CITY OF PORTLAND

Located At 27 DEDHAM ST

Job ID: 2012-07-4443-SF

From: Jonathan Rioux
To: JFGLCSW@hotmail.com; vjkavanaugh@hotmail.com
Date: 8/1/2012 2:28 PM
Subject: 27 Dedham St.

**STAIR SECTION**  
 SCALE: 1/2" = 1'-0"

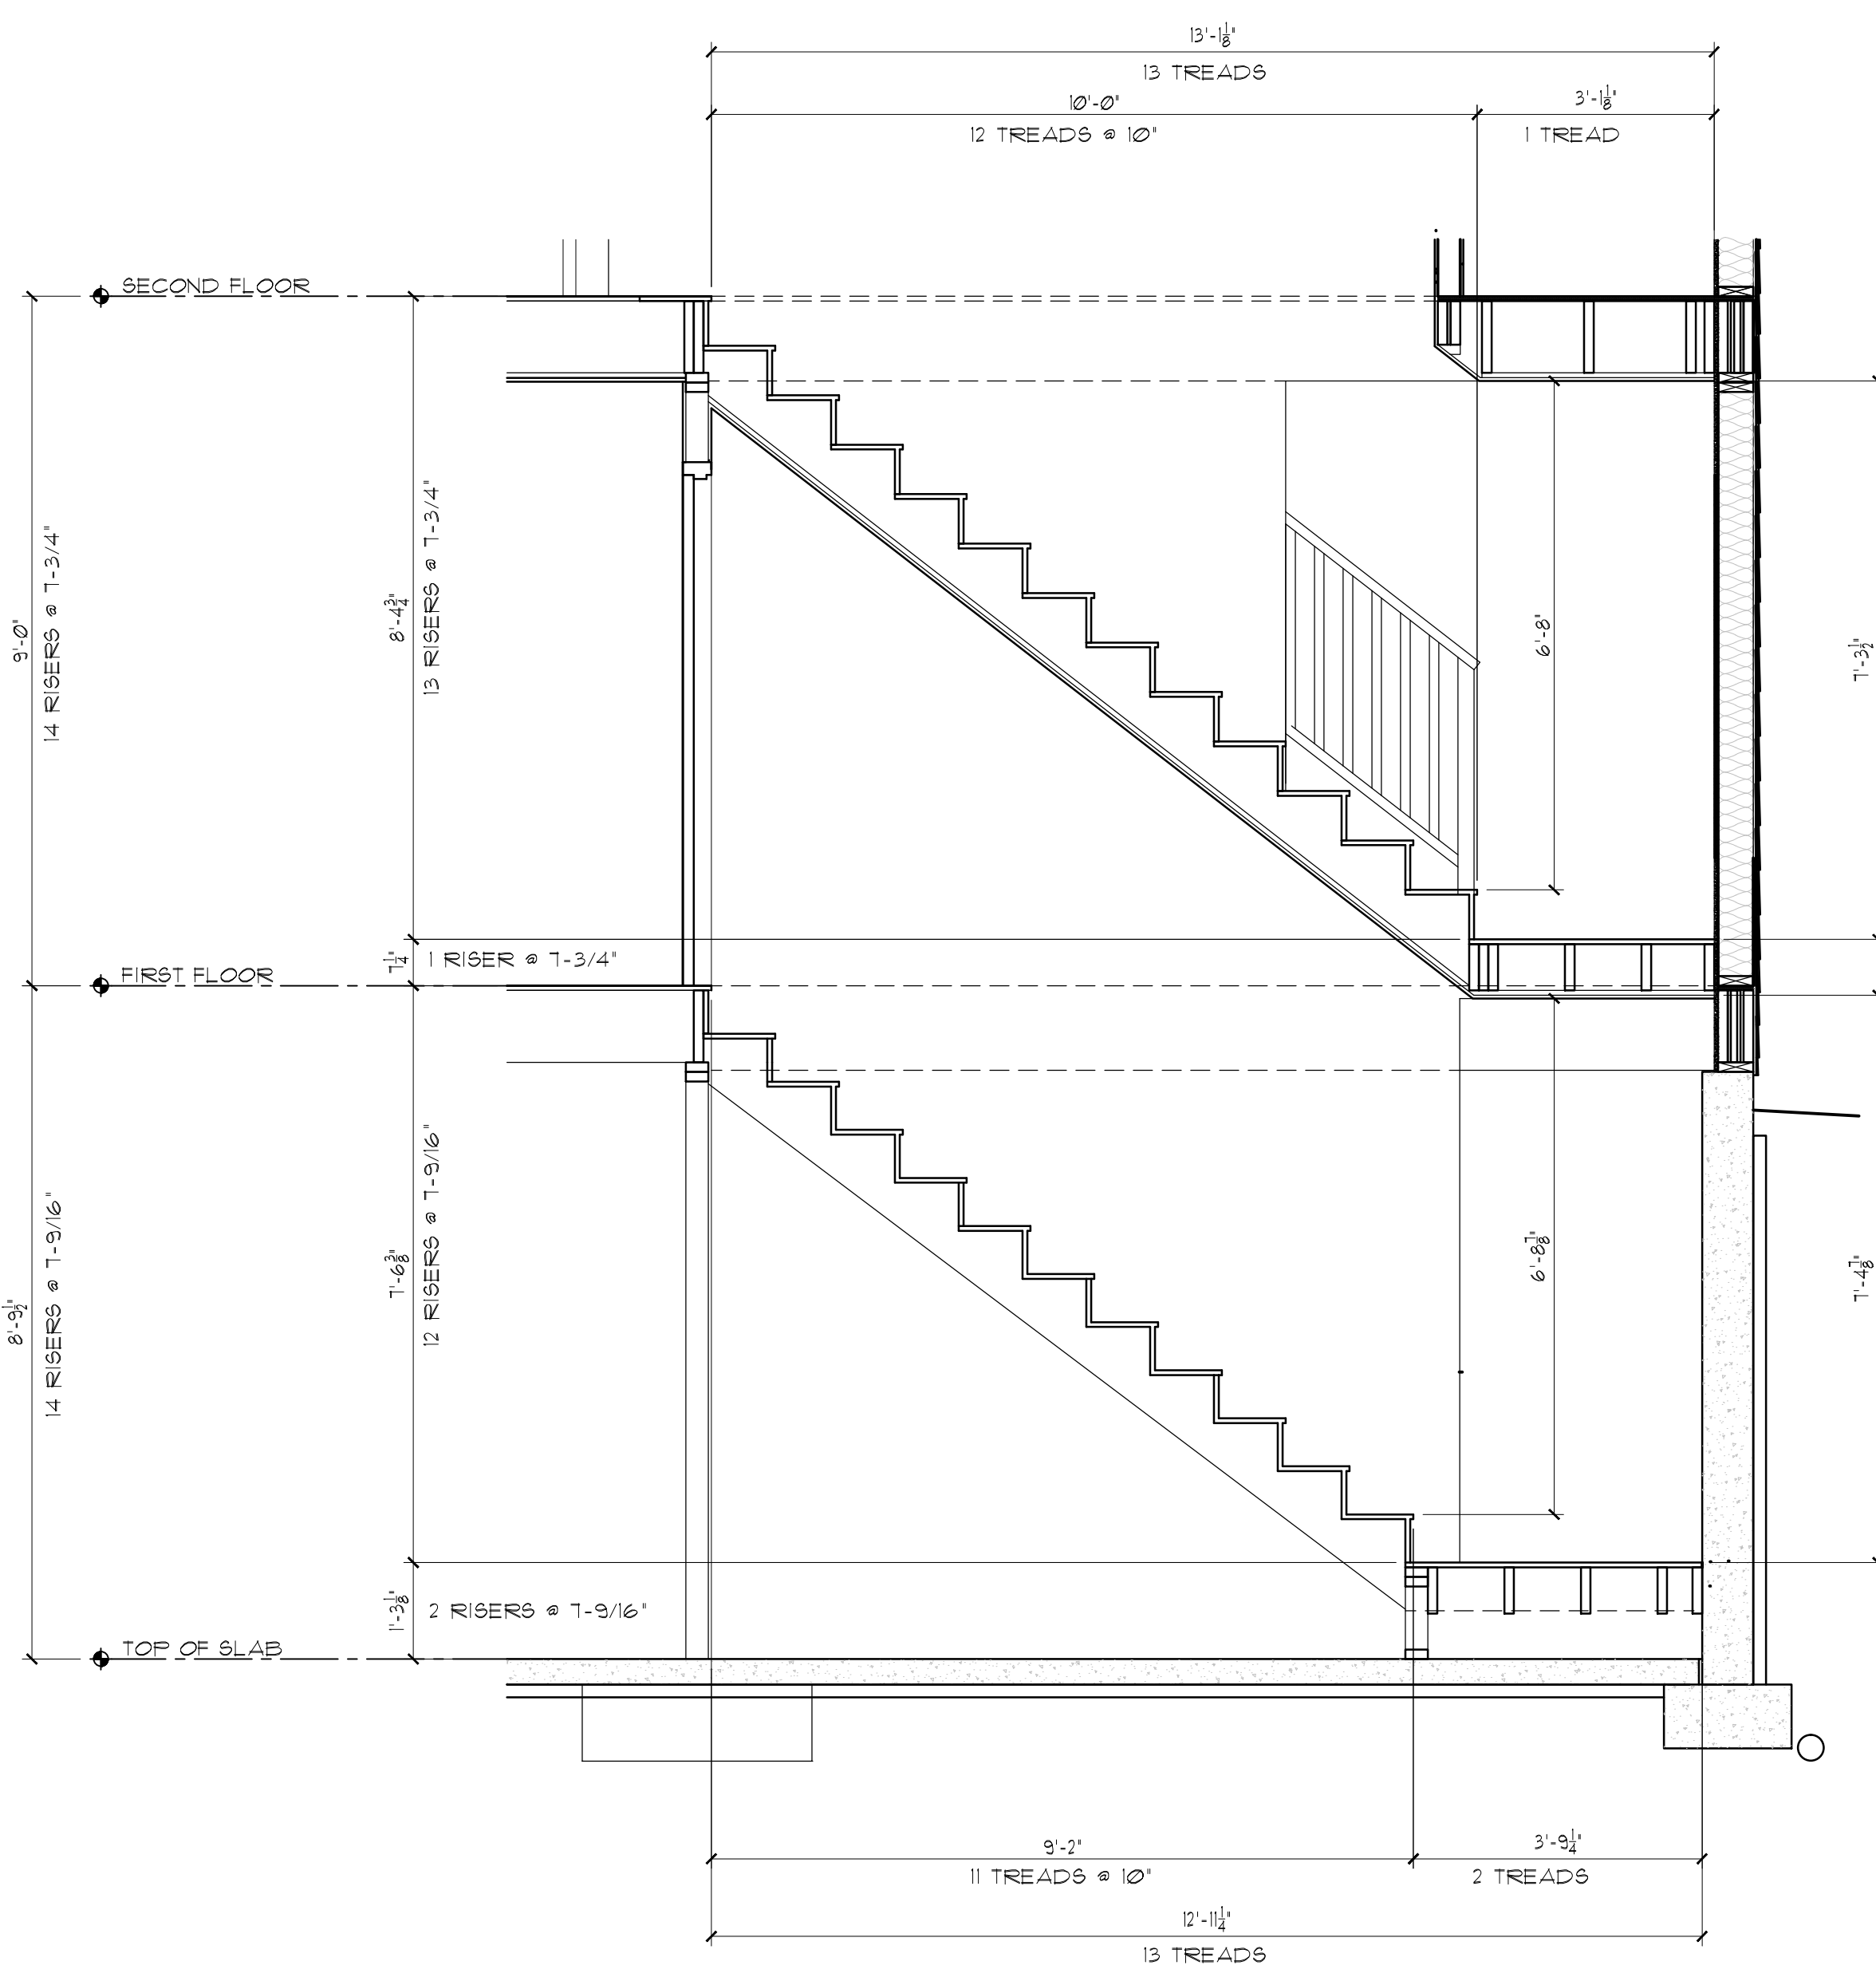
12. Stairway headroom shall be not less than 6 feet 8 inches measured vertically from the sloped plane adjoining the tread nosing or from the floor surface of the landing or platform?

DATE	06-24-12	NO	A	REMARKS	Issued for Permitting	BY	JJO
CODE:	IRC 2009						
TOWN:	Portland						
DATE:	06-24-2012						
SCALE:	As Noted						
DRAWN:	JJO						
TITLE:	SECTIONS						
FILE:							
SHEET:	A2-01

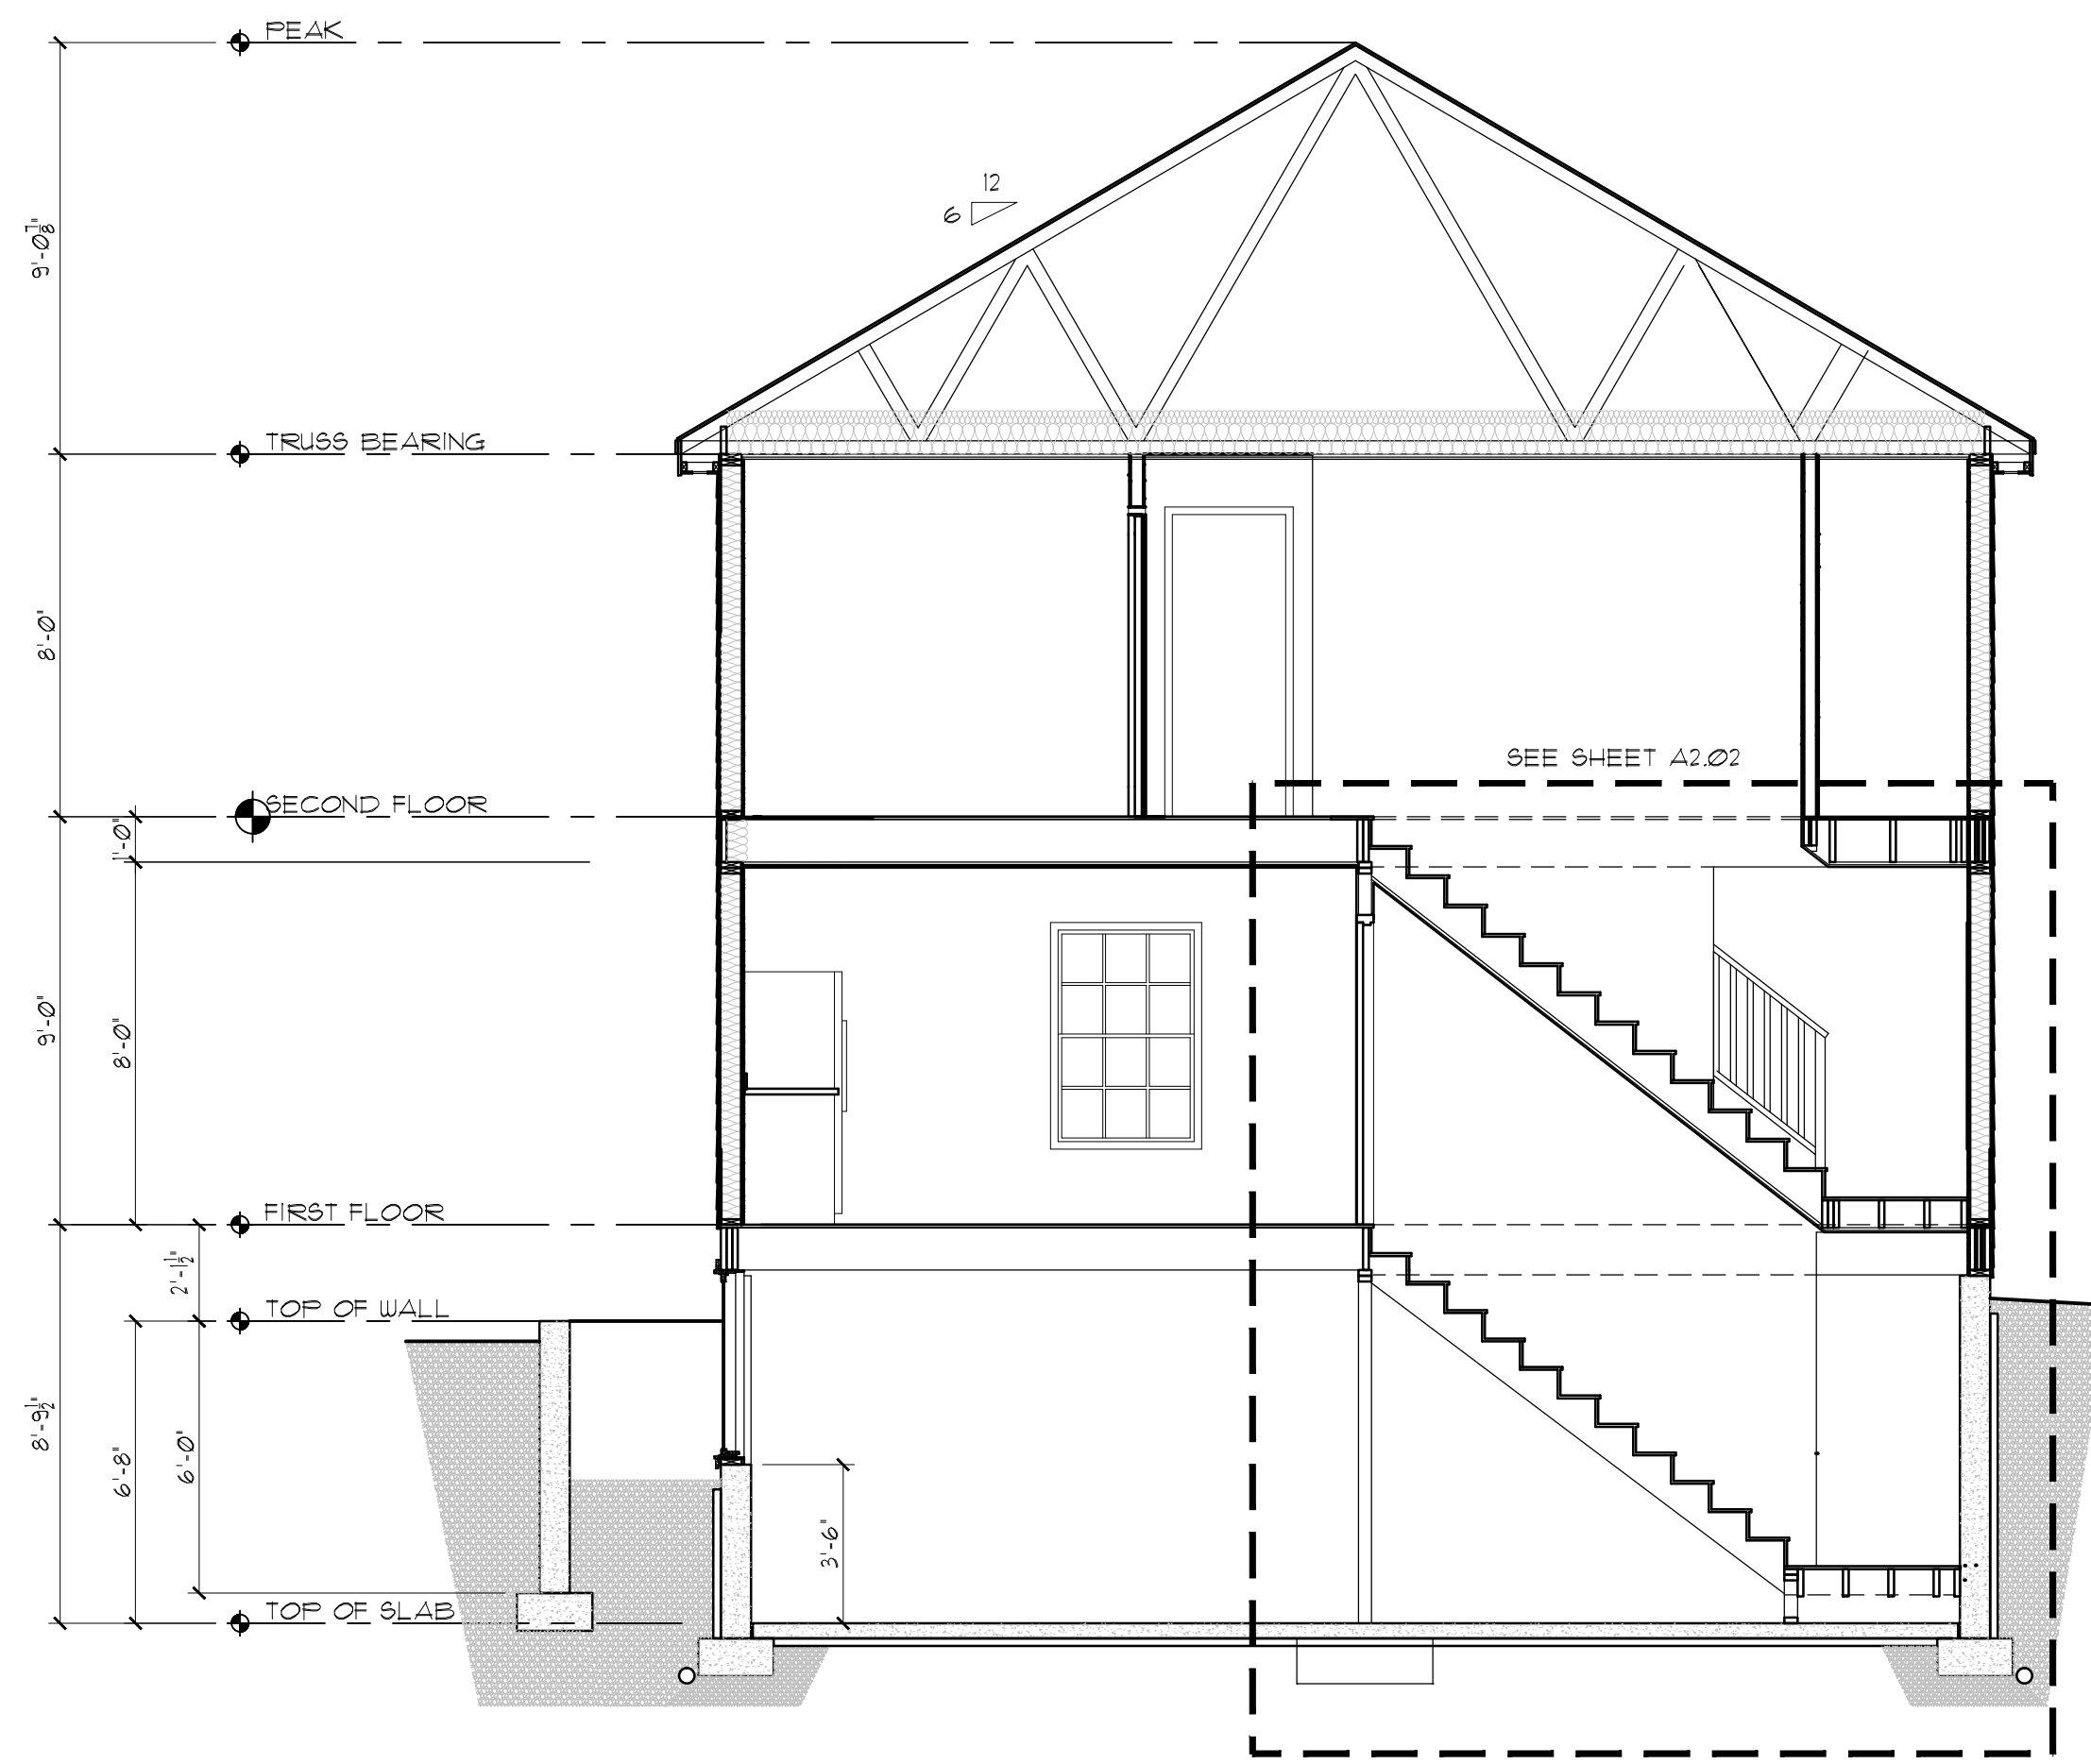
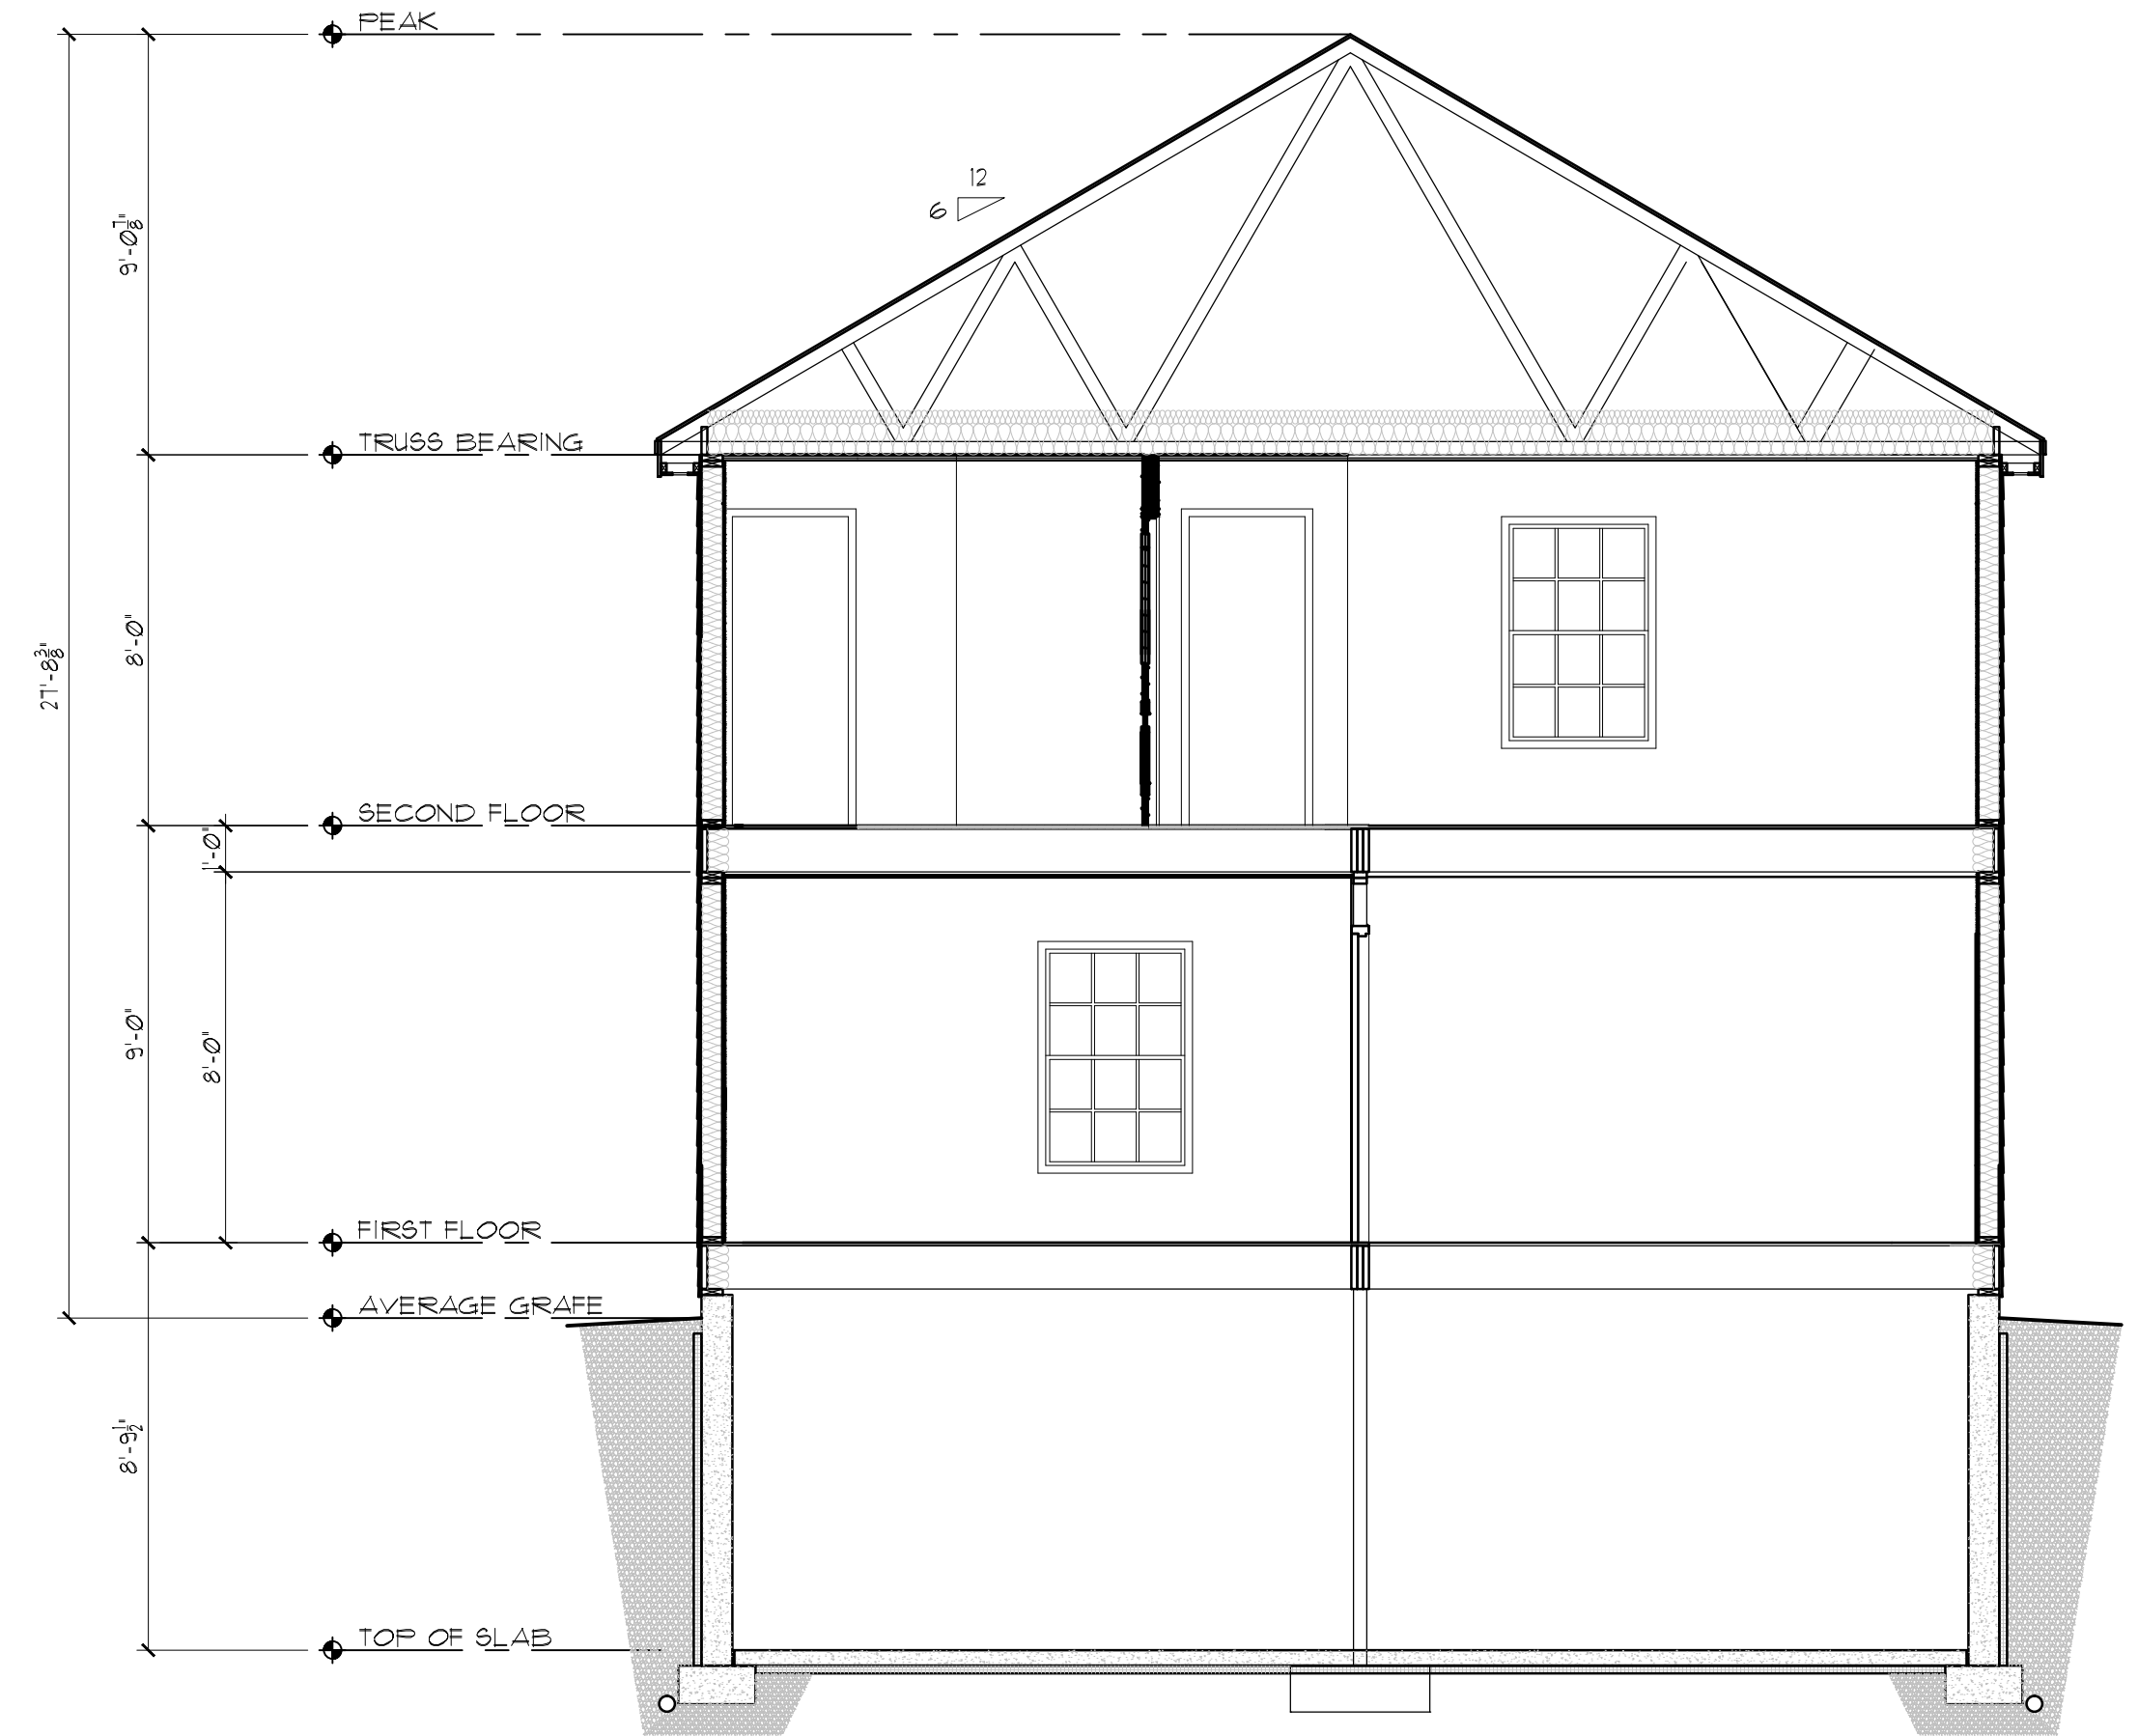
1. Anchor Bolts/Straps, spacing (Section R403.1.6) - Spacing at Corners?
2. Fabric, Damp proofing (Section R405 & R406)?
3. Lally Column Type (Section R407) Girder & Header Spans (Table R 502.5(2))- max span for (3) 2 x 12 inch Girders?
